May 30, 2024

Re: D&B U Sell It at 401 Unser Blvd. and 8530 Bluewater Rd. NW
Erosion and Sediment Control Plan
Engineer's Stamp Date: 1/7/2024 (K10E066)

Based on the information provided in your submittal, received on 5/23/24, the above-referenced ESC Plan can't be approved until the following comments are addressed.

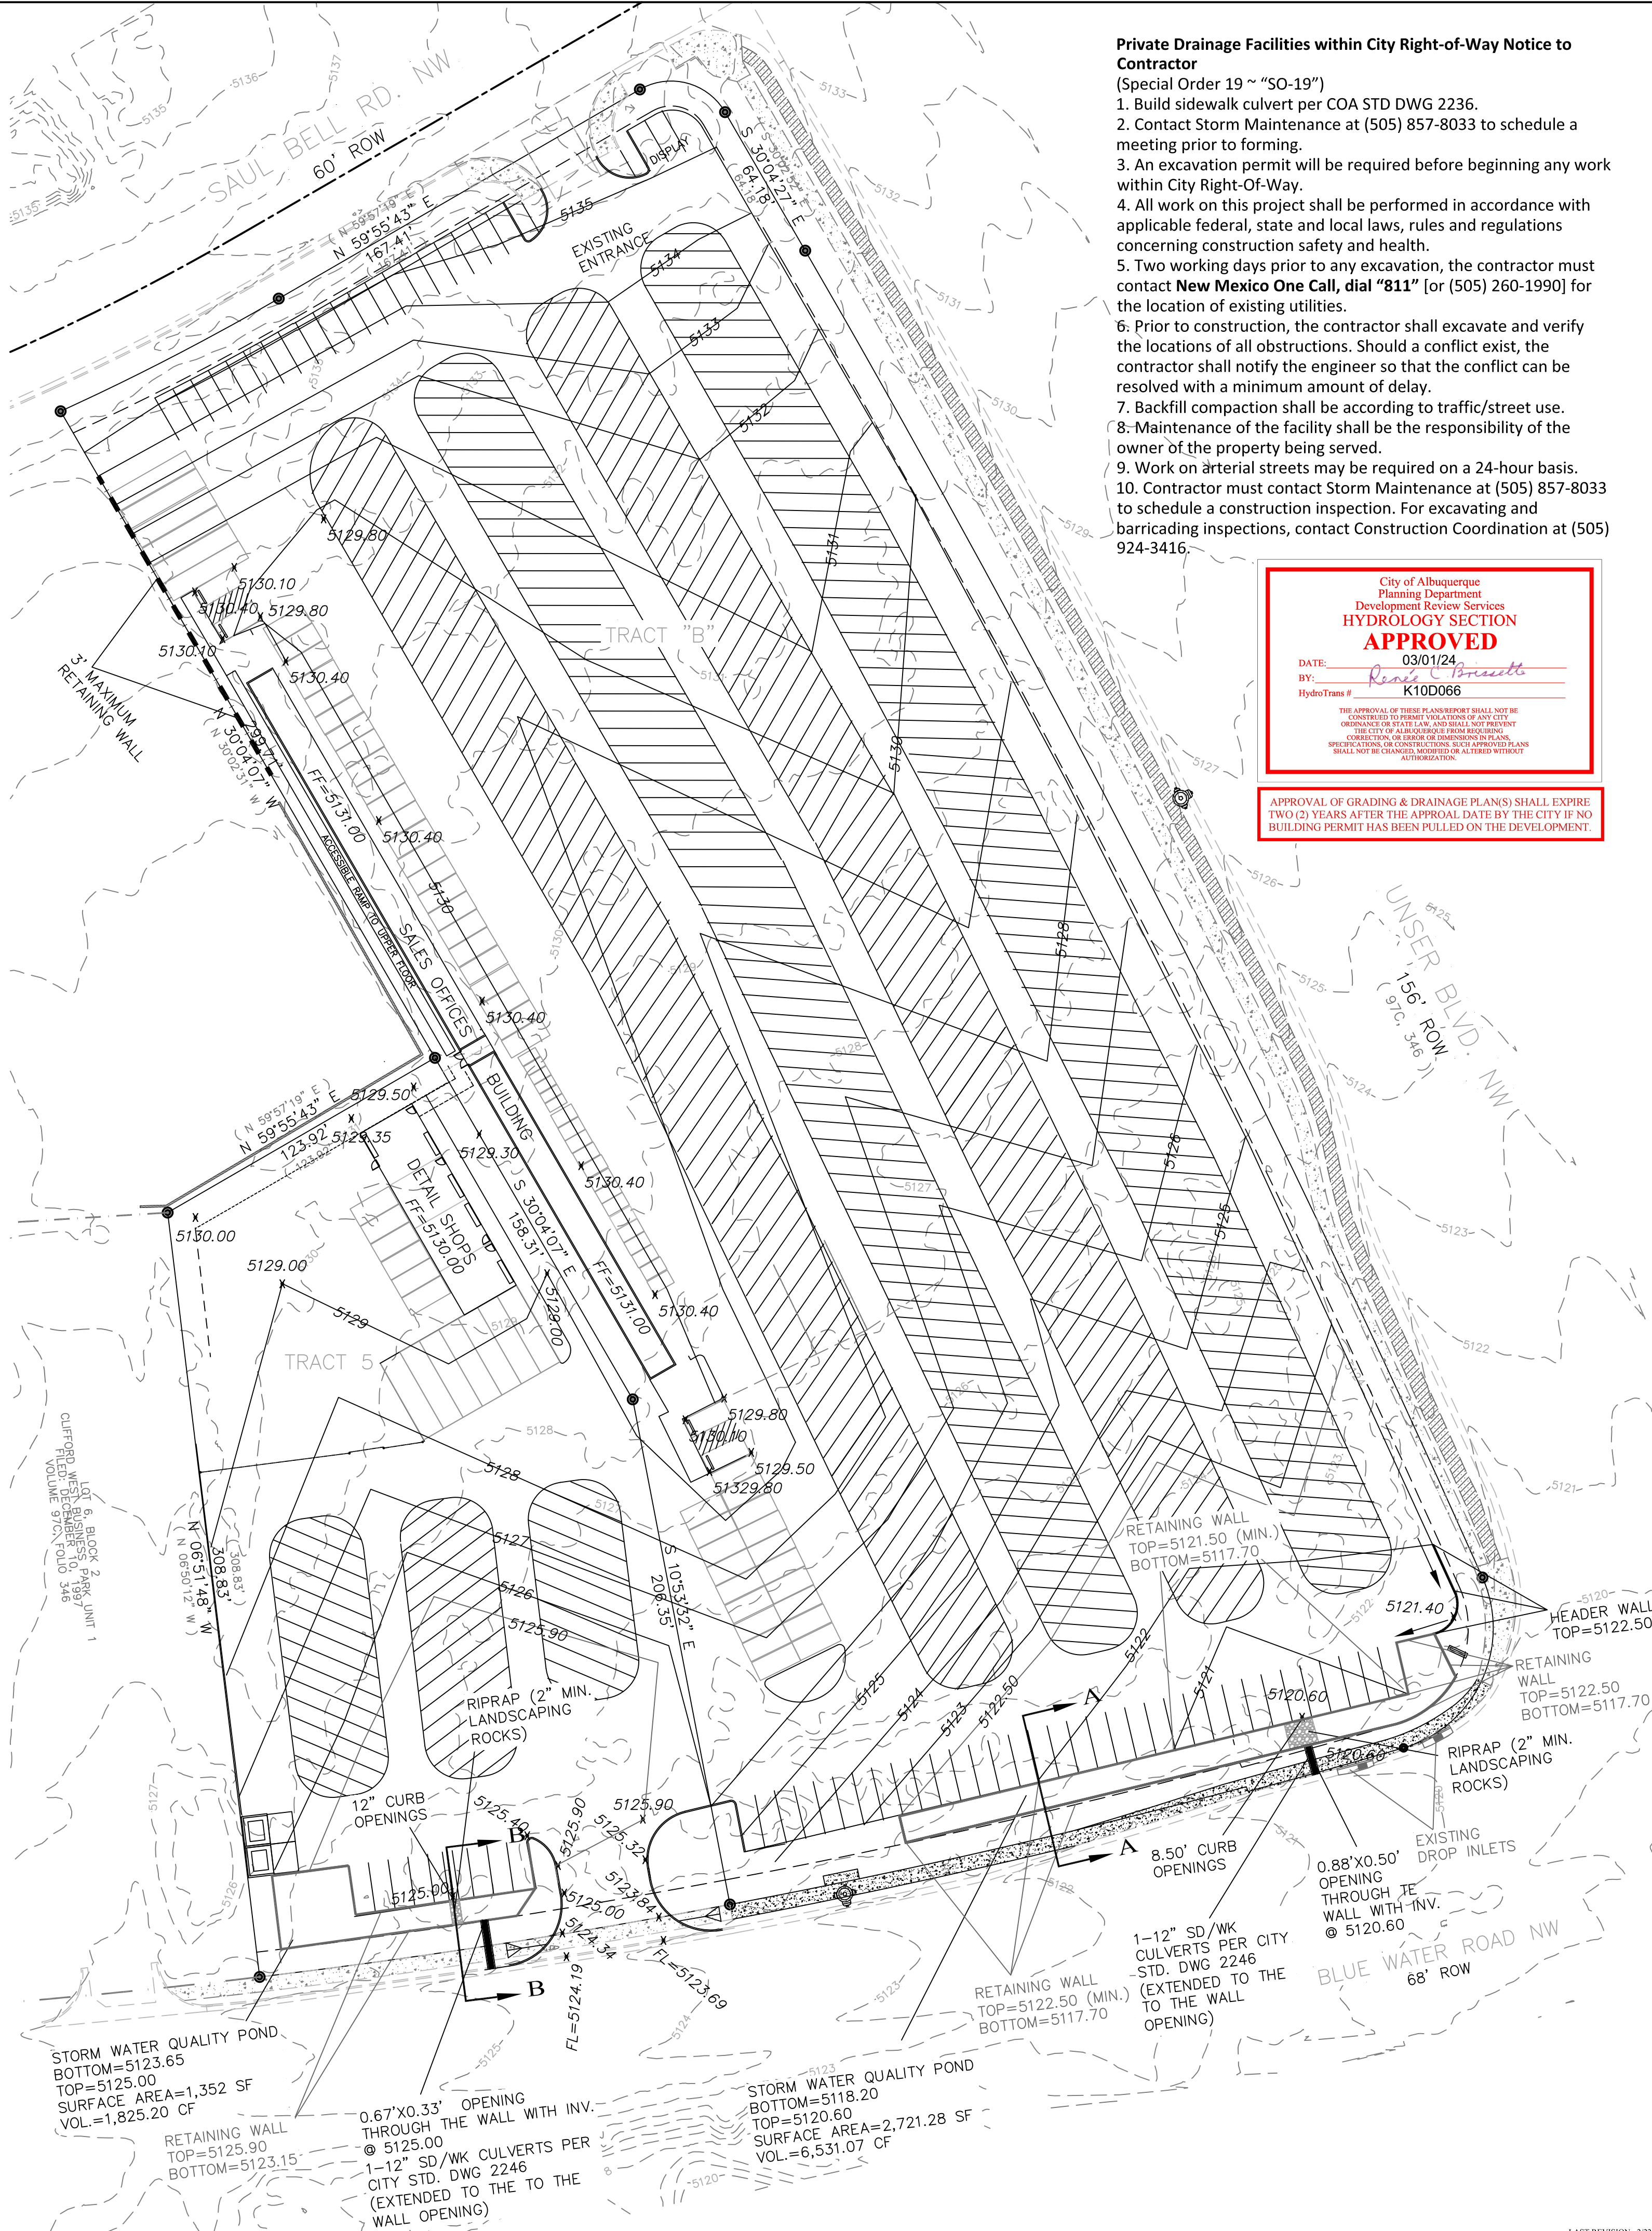
3. The ESC Plan must agree with the G&D Plan approved by Hydrology. The west sidewalk culvert is missing from the ESC Plan, and other elements of the approved G&D Plan may have changed. You must update the base map to agree with the approved G&D Plan.

6. Two Inlets along Unser Blvd are not shown on the plan, and inlet protection (IP) is missing at all 4 inlets. Show the location of all 4 inlets and IP at each.
